**RE: SUBMISSION TO SSD-83431958 FOR CONSTRUCTION OF 9 STOREY
RESIDENTIAL FLAT BUILDING WITH IN-FILL AFFORDABLE HOUSING**

Address: 16 & 18 Middle Harbour Road, Lindfield

ATTACHMENT 1

Ku-ring-gai Council's objection to SSD-83431958, for construction of 9 storey residential flat building with in-fill affordable housing at 16 & 18 Middle Harbour Road, Lindfield

DRAWING TITLE:  
**SHADOW DIAGRAMS- JUNE 21  
 9AM**

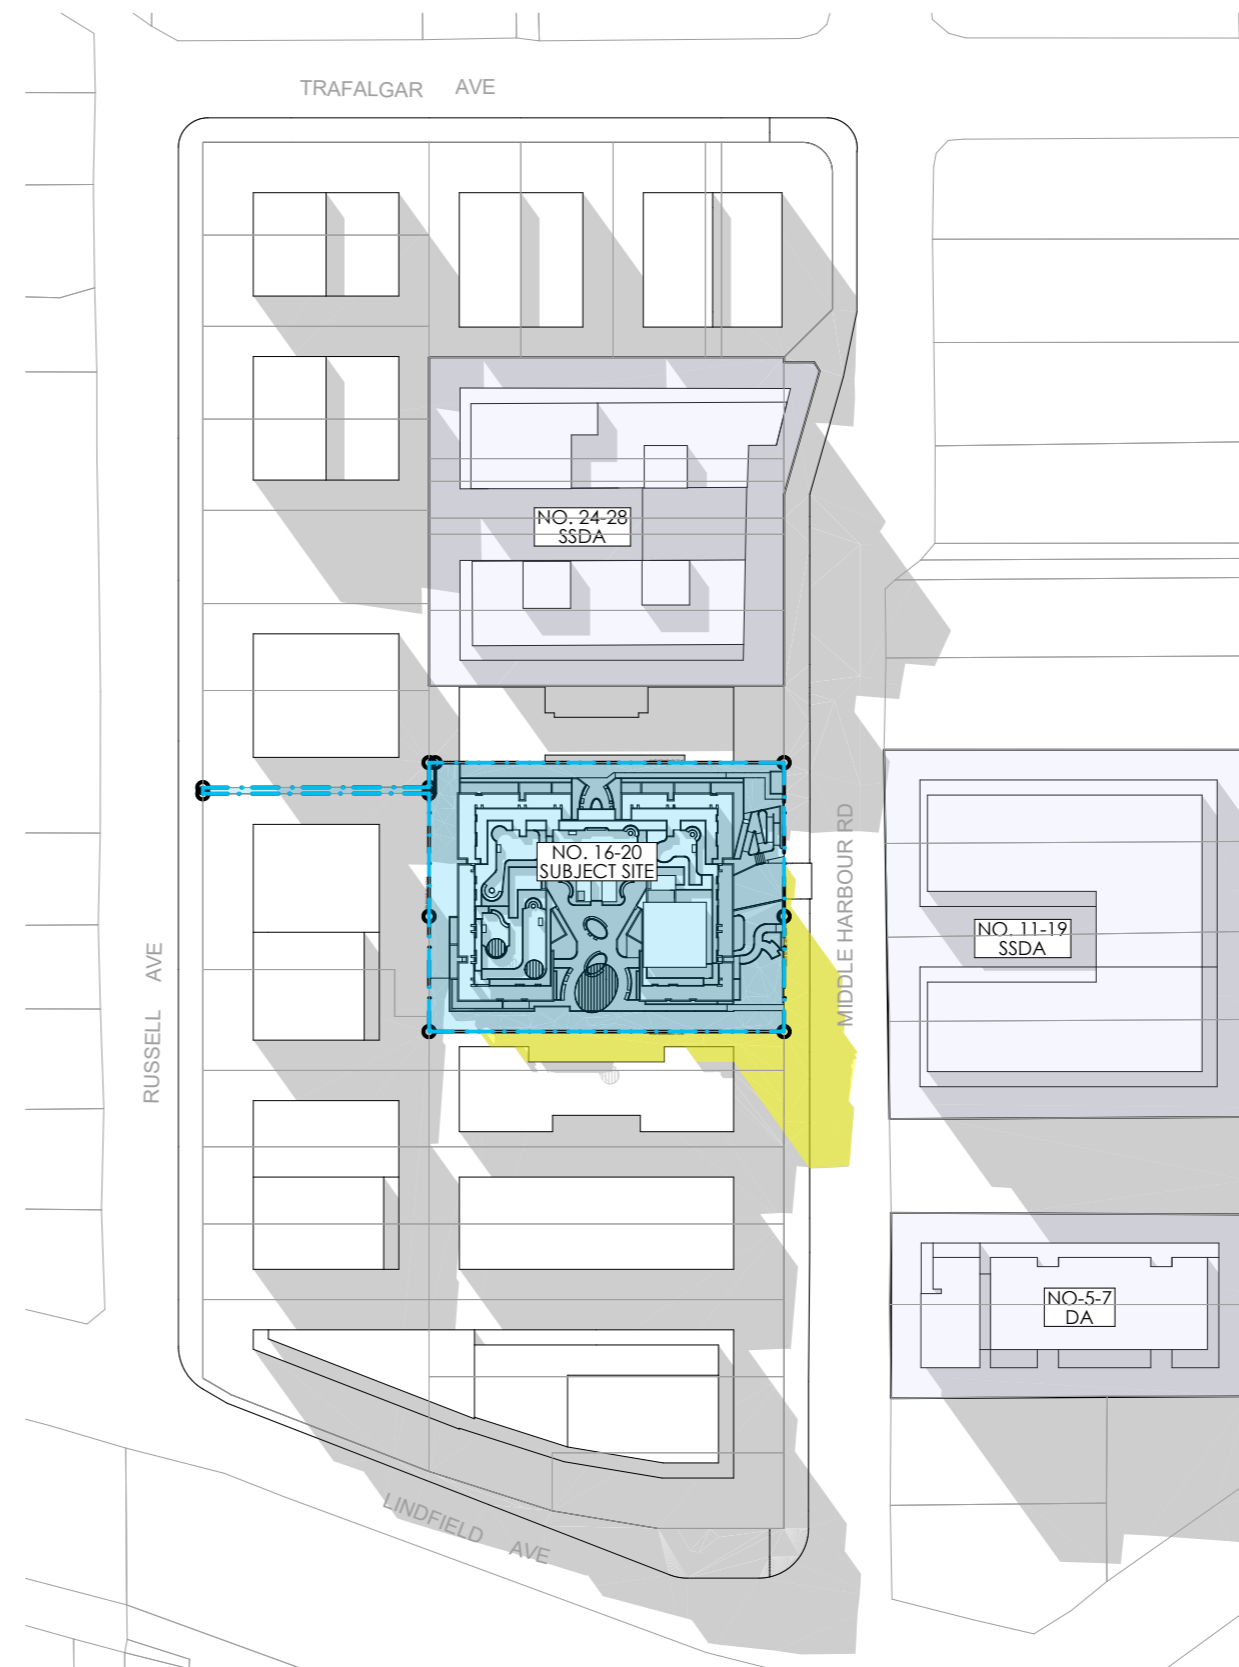
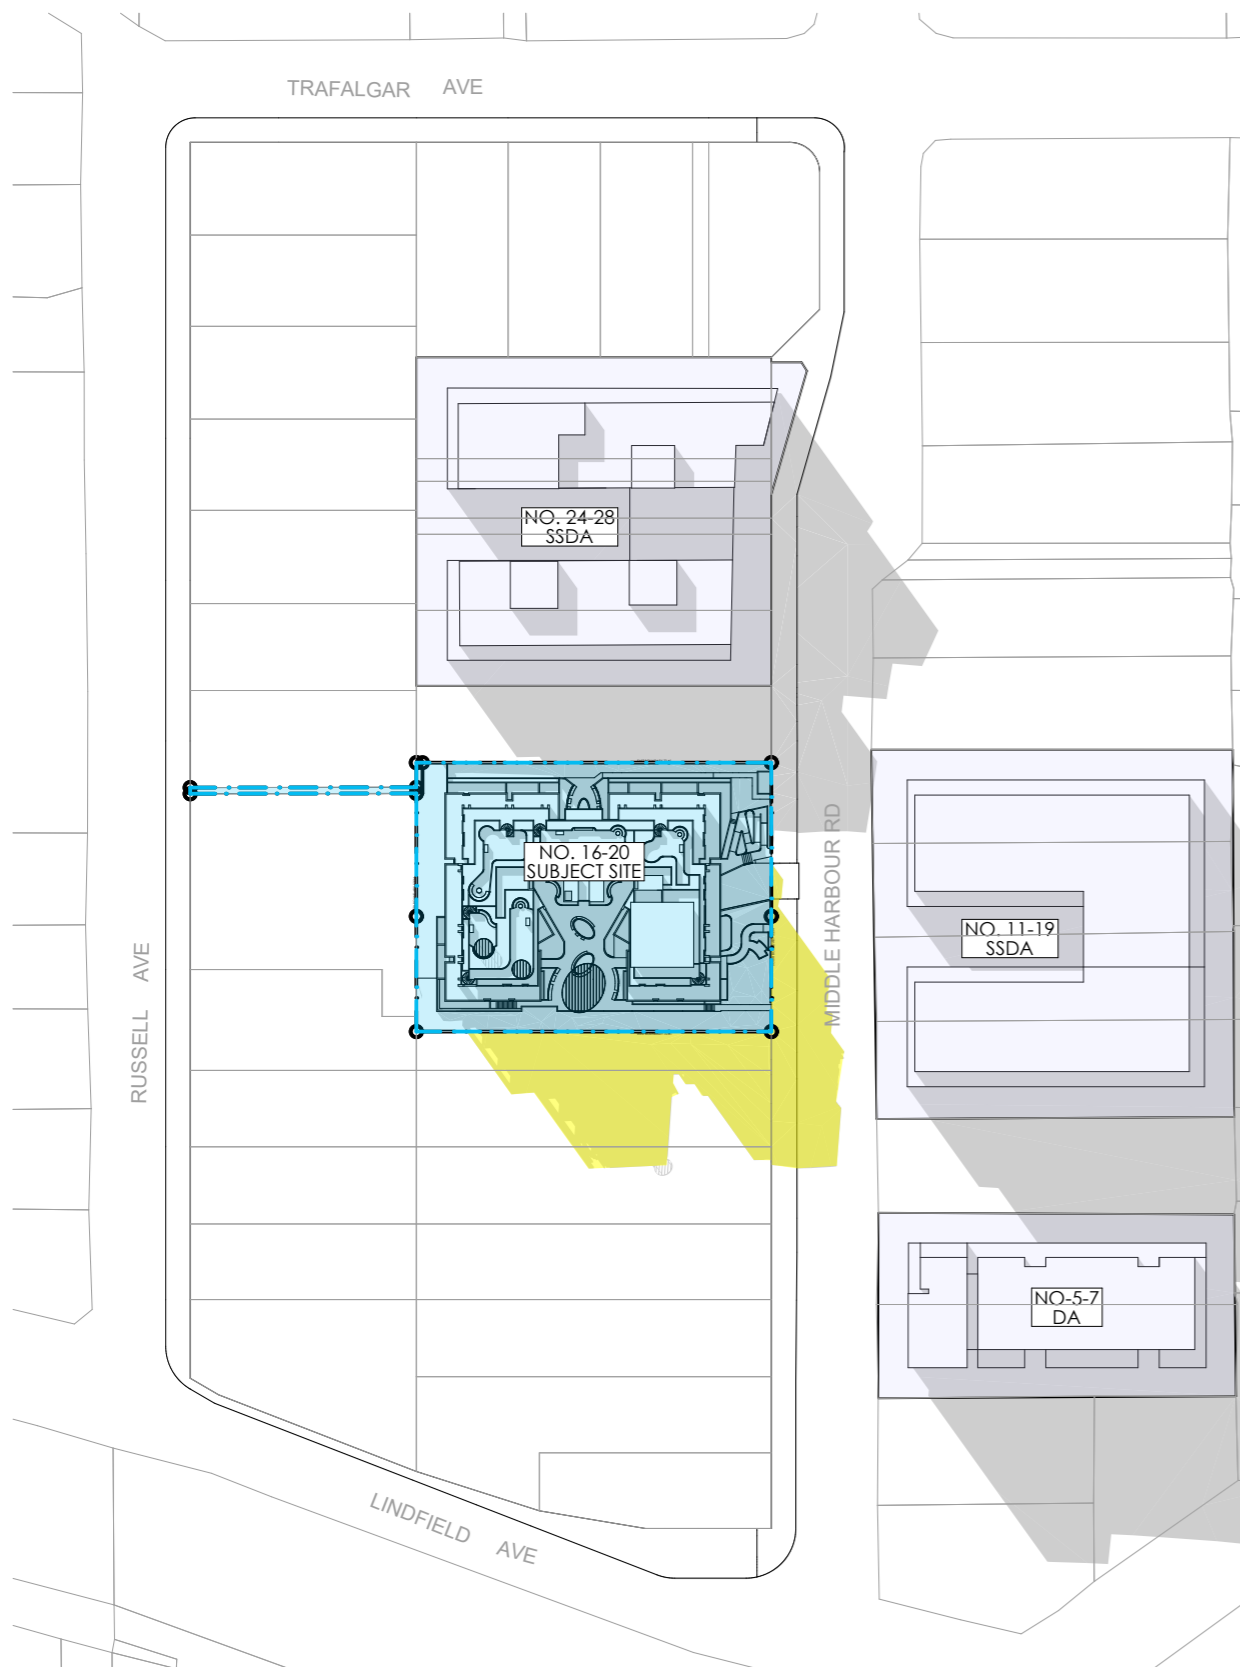
- Overshadowing of adjacent properties (ADG 3B): Shadow analysis is incomplete and does not compare against the compliant 22m base height under Chapter 5 of SEPP (Housing) 2021, therefore full extent of shadow impact from the infill "bonuses" under Chapter 2 of SEPP (Housing) 2021 are unknown. Further, no elevational shadow diagrams were prepared demonstrating impact on existing and future development.

The maximum height under the relevant controls is 22metres, with an allowance for bonus height under the In-fill Affordable Housing provisions. The submitted documentation suggests the proposal reaches a height of approximately 28.6 metres, reflecting the full 30% bonus. However, the shadow analysis provided is incomplete. It does not clearly assess the impact of overshadowing on existing neighbouring low-density residential dwellings, nor does it illustrate the difference between a compliant 22m form and the proposed building height. The additional overshadowing impacts on adjoining properties as a consequence of the infill affordable “bonuses” are therefore unknown

In the absence of this comparative analysis, the overshadowing impacts cannot be properly assessed. Based on the submitted material, it appears that the proposal will significantly increase overshadowing on adjoining properties, with no justification for exceeding the 22m height control. The failure to demonstrate compliance with ADG objectives or to transparently assess the additional impacts of the bonus height is a critical deficiency. A reduction in height and GFA is required to mitigate unacceptable overshadowing on neighbouring residential properties.

Elevational shadow diagrams and/or view from sun diagrams must be prepared that clearly indicate the proposed heights at 22m and 28.6m and overshadowing impacts on both existing and future development on adjoining properties.
